Your Ref: OWQC17537
Our Ref: BE/17/18/PL
Please ask for:
Mr S Davis

Proposed 2 bed bungalow
37 Norbren Avenue Bersted

Thank you for your internet comments made on 8th March 2018 which has been recorded as '**an objection**' with the comments as follows:

PROJECT	Proposed Bungalow 37 Norbren Avenue, Bognor Regis		
TITLE	Proposed Ground and First Floor Plans		
CLIENT	Mr & Mrs Clarke		
SCALE	1: 100	DATE	16/09/2017
DRAWING NO.	906-01	rev.	.

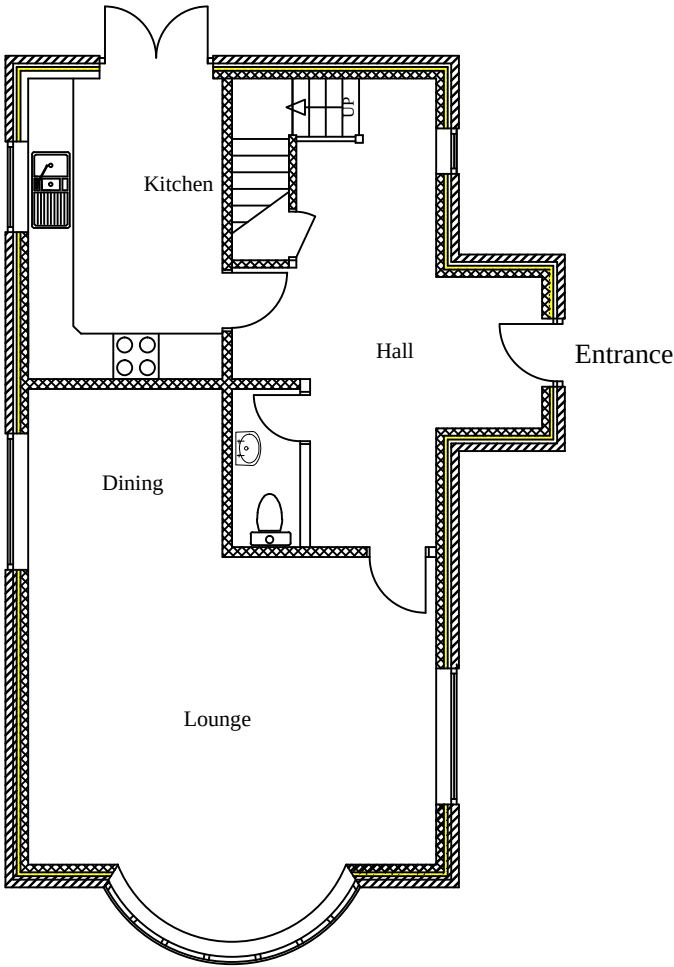
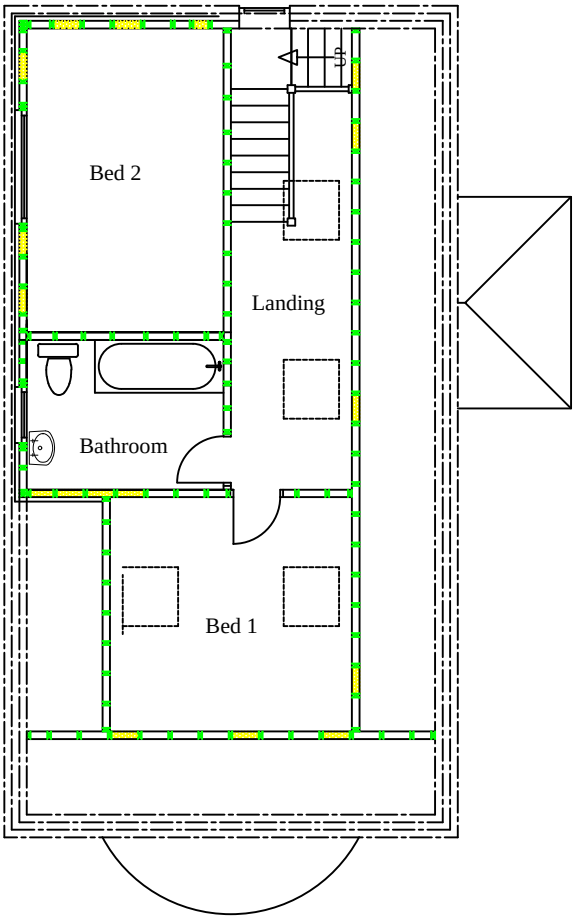
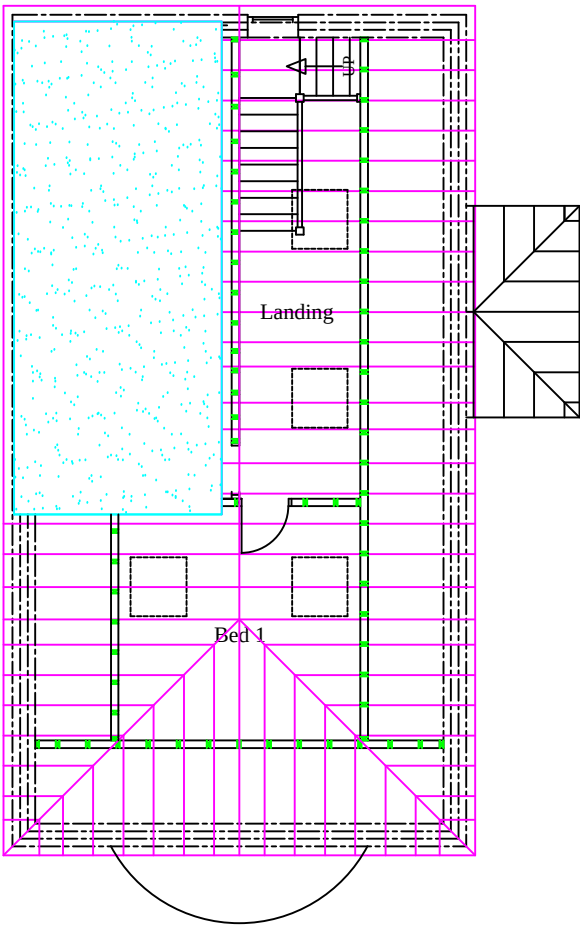
HDQ8 as it is not clear whether there is adequate parking, which may lead to on street congestion.

Overdevelopment of the site.

Farhad Aarabi	
PROJECT	Proposed Bungalow 37 Norbren Avenue, Bognor Regis
TITLE	Proposed Elevations
CLIENT	Mr & Mrs Clarke
SCALE	1: 100
DRAWING NO.	906-02
DATE	16/09/2017
rev.

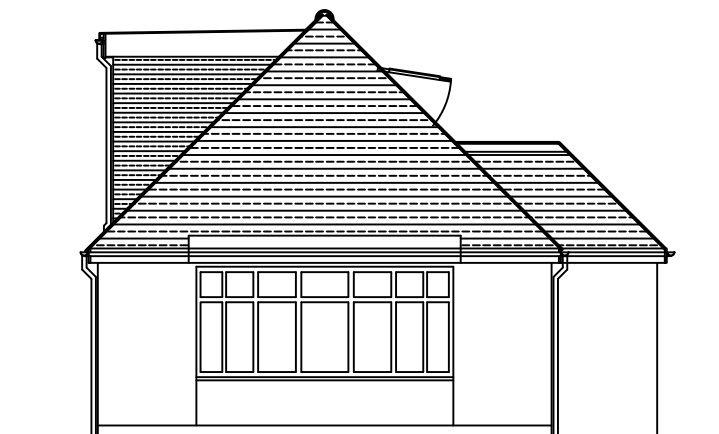
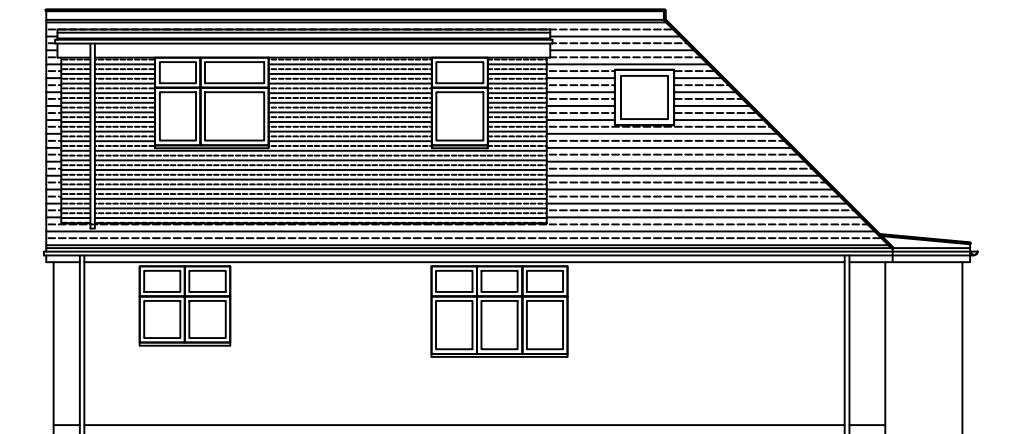
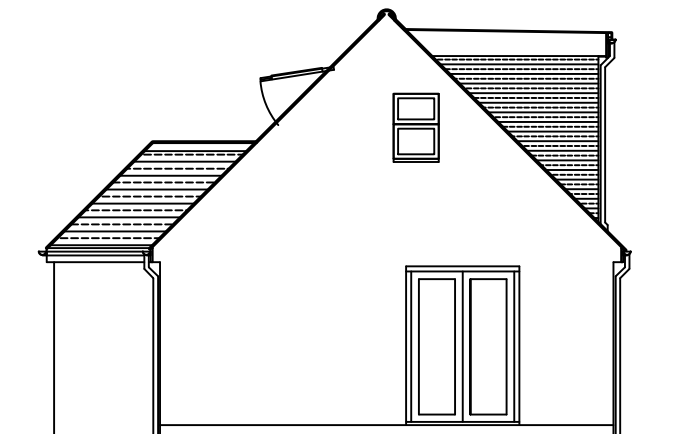
HDQ5 regarding the design, character and integration with the surrounding houses in the area.
